Application for Planning Permission for Works or Extension to a Dwelling

Development New single garage at front of dwelling and conversion of existing garage to habitable accommodation.

Location 67 Golden Avenue East Preston

SITE PLAN SCALE 1:500

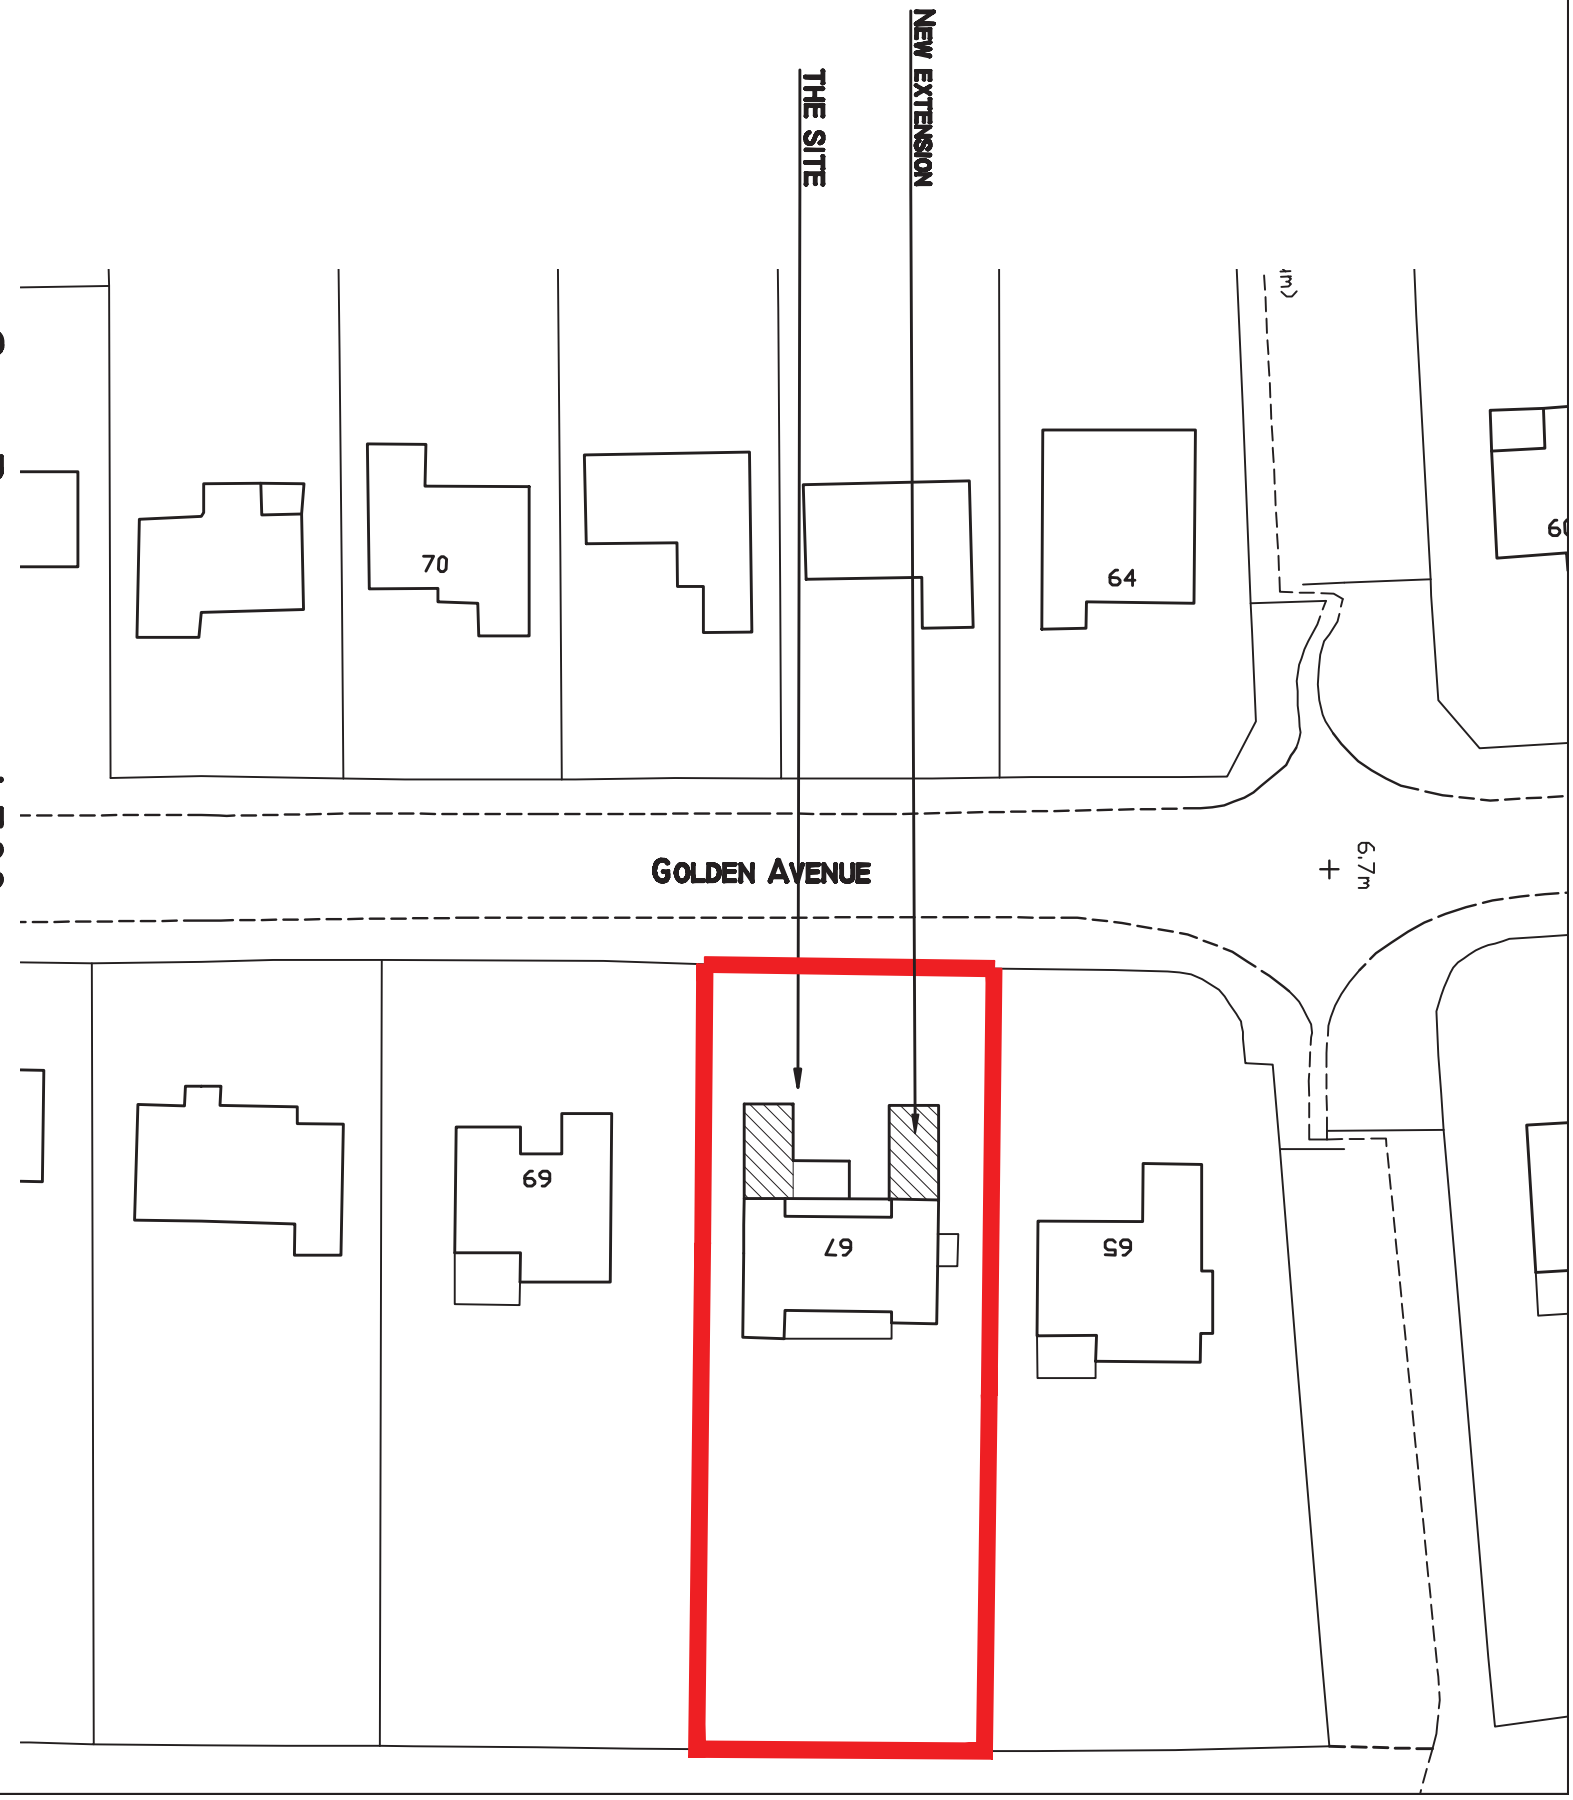
Please submit amended block plans to show all proposed works highlighted
